Paul and Tania Hagan
2/3 Robert Road
CHERRYBROOK NSW 2126
02 9659-0922 / 0413 884-978

2 December 2012

**NORTHWEST RAIL LINK (NWRL)
RELEASE OF ENVIRONMENTAL IMPACT STATEMENT (EIS2)
APPLICATION NO: SSI – 5414**

Figure 6.12 Cherrybrook Station - Indicative vehicle and pedestrian movements

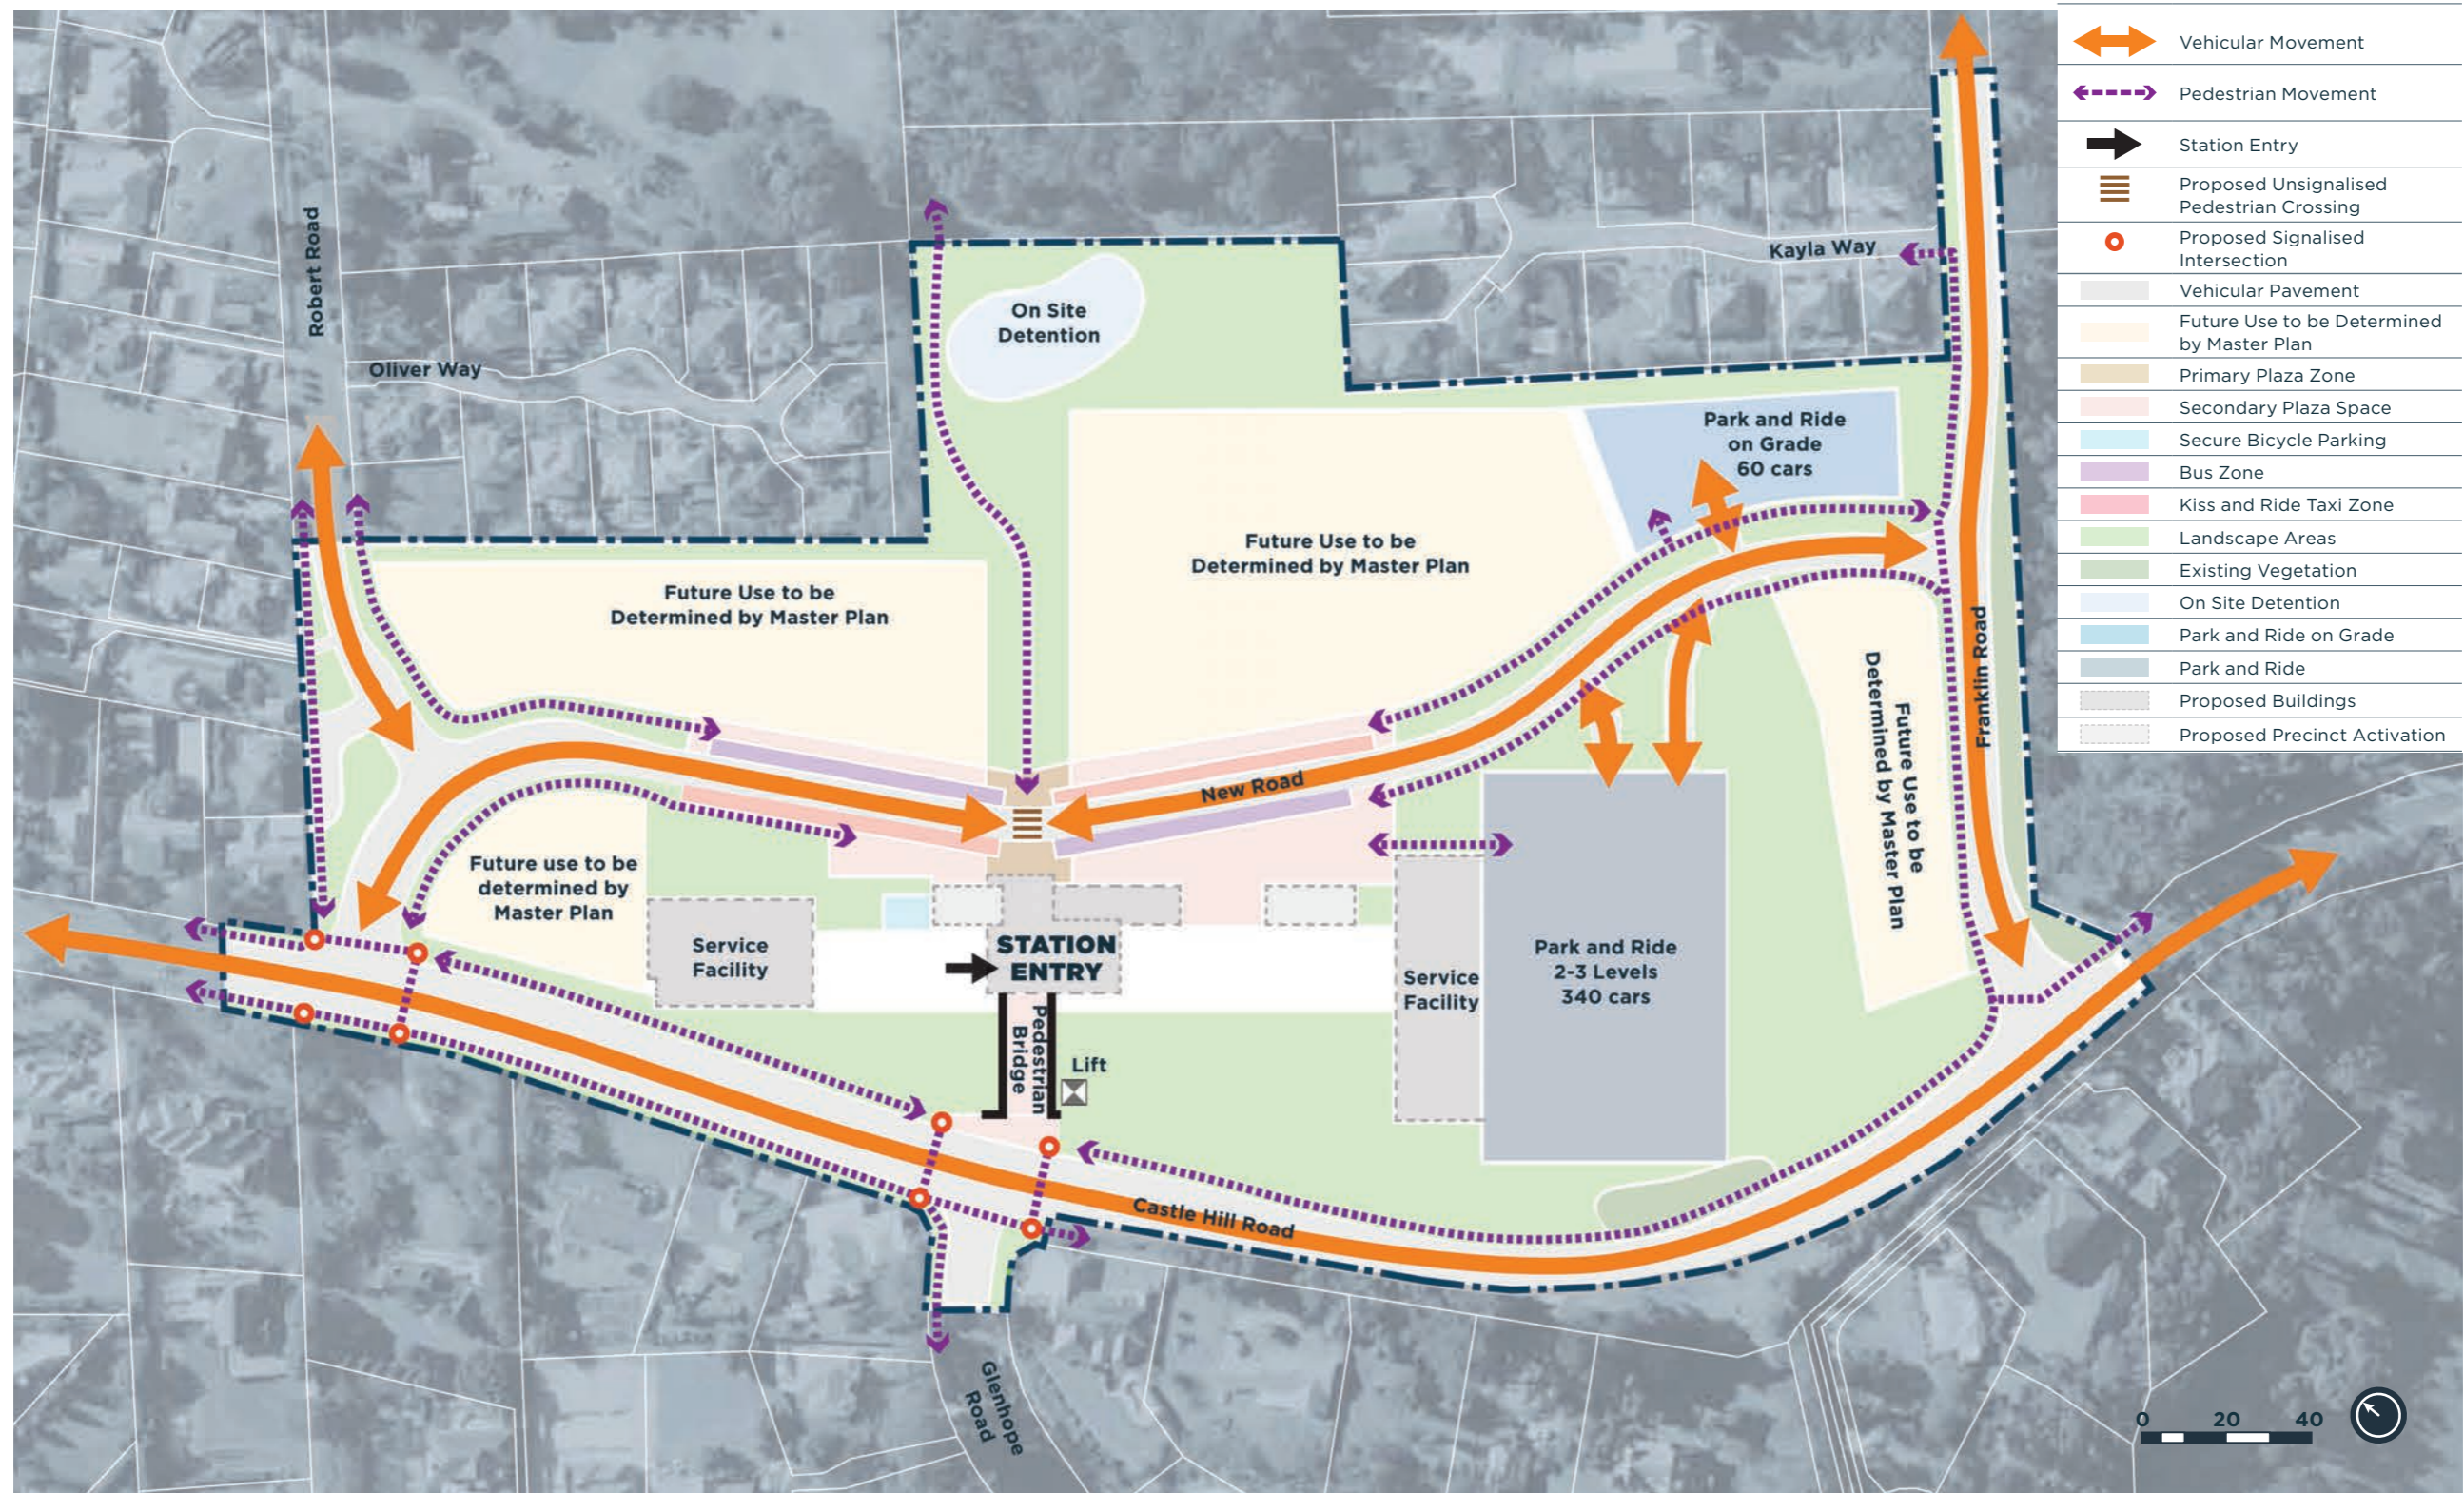
1. Robert Road was never supposed to be used as a feeder road for the new station. The entry and exit points were always Castle Hill Road and Franklin Road. The arguments given by the NWRL for using Robert Road are simply flawed and based on no real traffic analysis of the area. There is absolutely NO reason to utilise Robert Road when the use of County Drive and Castle Hill Road are under-utilised and are perfect for this purpose. An independent traffic analysis company commissioned by the residents of Robert Road prove the following:
 - a. Currently the bus stops on John Road during AM and PM peak periods are under-utilised. To suggest that buses need to run up John Road and Robert Road to

- b. The traffic currently utilising Robert Road is at a maximum capacity given its size which is 7 metres wide. To send a bus on Robert Road every 3 minutes during peak periods and a minimum of 50% of vehicular traffic travelling to the Cherrybrook Station on Robert Road will create a very hazardous and a dangerous situation. Consideration must be given to how many estates link to Robert Rd, how narrow Robert Rd actually is, and how many young children and elderly people live on Robert Rd. Are you honestly proposing that Robert Road can handle the extra traffic over County Drive?

On a more personal level, the proposed diagram in EIS2 of the future Cherrybrook Station setting out the barrier in front of our property is purely impractical and cannot work. At 3 Robert Road there are 4 houses all sharing a narrow driveway with no turning circle. Currently 10 vehicles use this driveway for residents to enter their respective homes. There is no turning circle and no visitors parking. All of us rely on onstreet parking because of this. With the proposition made by the NWRL that they plant a few bushes on either side of the driveway is totally unacceptable as some sort of compensation to alleviate noise and protection from the entry into the future Cherrybrook Station. This simply cannot work as we've mentioned there is no turning circle so we have to reverse out of our driveway. This means that we will be reversing on to a major busy road with absolutely no vision because of the trees planted. We propose the barrier as suggested by the NWRL in the EIS2, to be extended past our property so we can safely access Robert Road and have some parking. We have two proposals.

1. Diagram 1 - Acquire the empty block of land at 8 Robert Road which will give the NWRL ability to sufficiently move Robert Road further east allowing a barrier to protect and extend from 5 Robert Road to the corner of Robert Road and Castle Hill Road. This would give all these homes the maximum amount of protection from noise, traffic and lights expected to be generated from the future Cherrybrook Station. This suggestion we feel is only a slight amendment to what the NWRL has proposed.
2. Diagram 2 – Absent of acquiring 8 Robert Road, we propose the barrier be extended past 3 Robert Road.
